DOC16/607065  
EF16/3389

**Mayfield Resource Recovery Facility SSD 7698 – 1a McIntosh Drive, Mayfield West, Newcastle**

I refer to the State Significant Development (SSD) 7698 and environmental impact statement for the Mayfield West Recycling Facility, located at 1a McIntosh Drive, Mayfield West.

Figure 2.2 Water management system layout

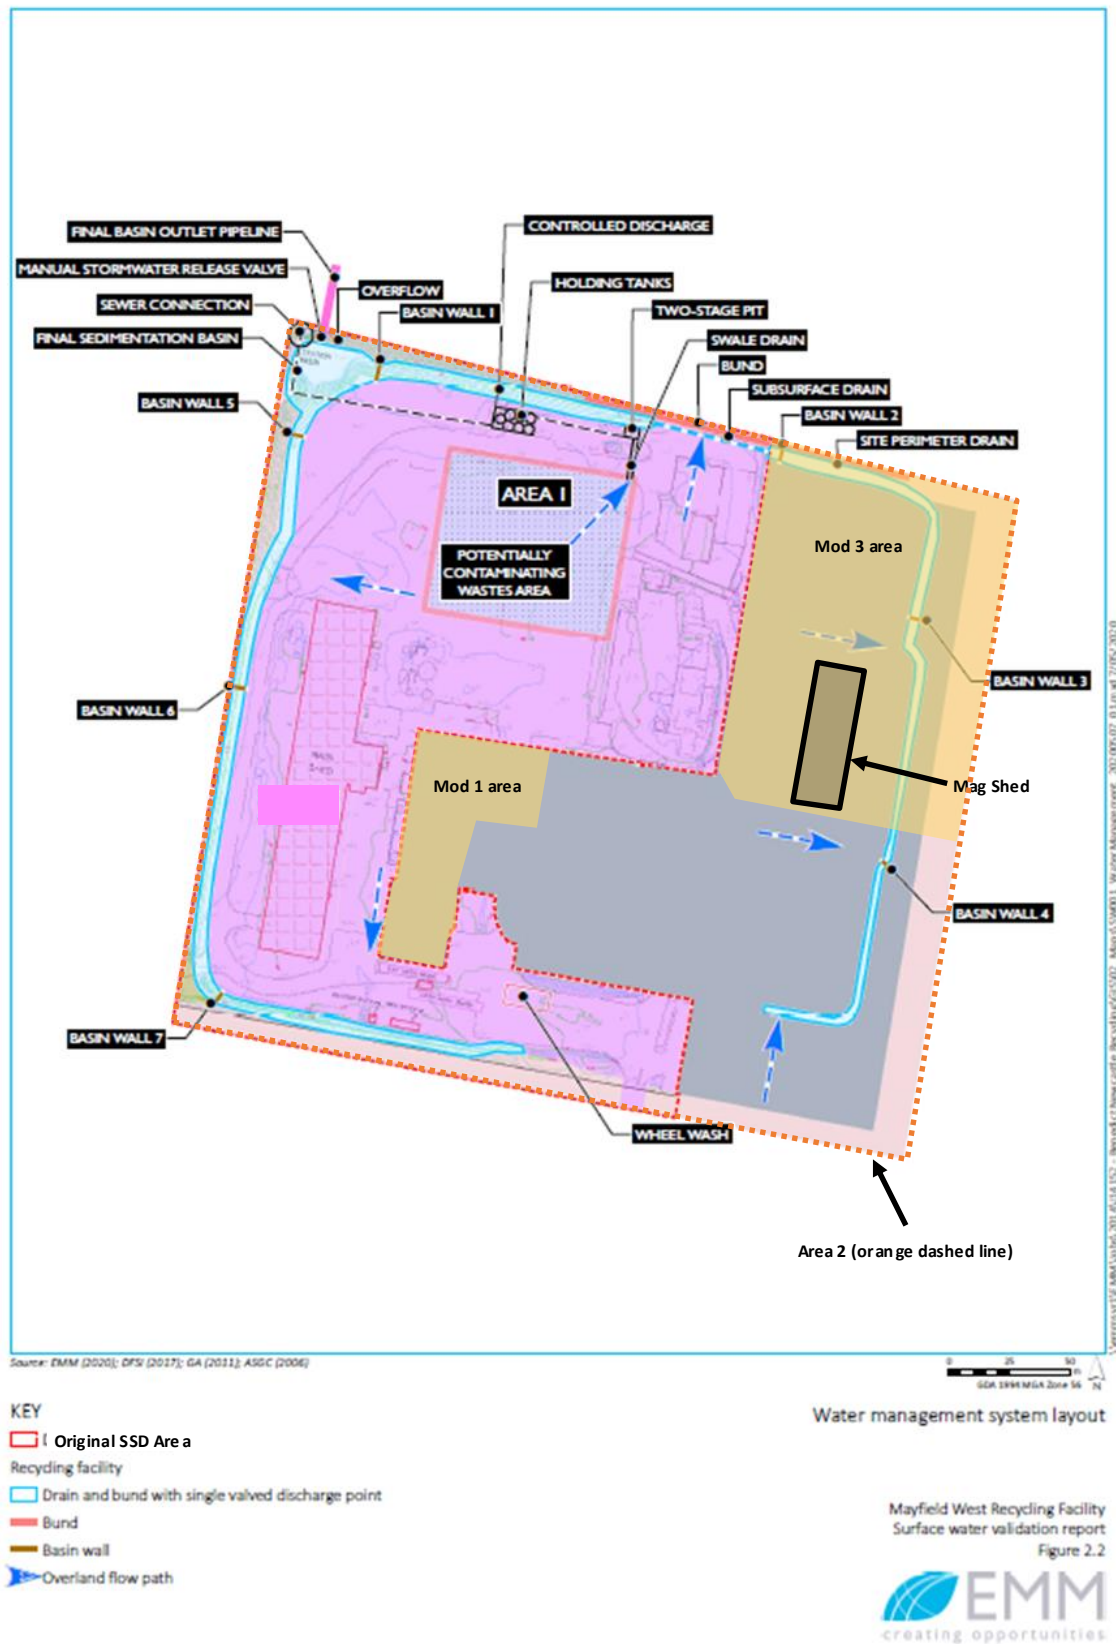
The proposal includes a greater area of stockpiled waste and therefore increases the volume of contaminated run-off collected by the perimeter drain and final sediment basin. However, there is no corresponding increase in the size of the sediment basin so that adequate management periods to settle sediment are in place.

Sediment basins are not designed to treat oil and grease and other toxicants. Sediment basins and sizing of sediment basins in accordance with the *"Managing urban stormwater: soils and construction"* publications is based on sediment that is not affected by other potential pollutants. An increase in loads of these toxicants is not acceptable and toxicants require suitable prevention or treatment in relation to discharges.

It is recommended that the above deficiencies in the Water Assessment are addressed prior to the EPA providing recommended conditions of approval.
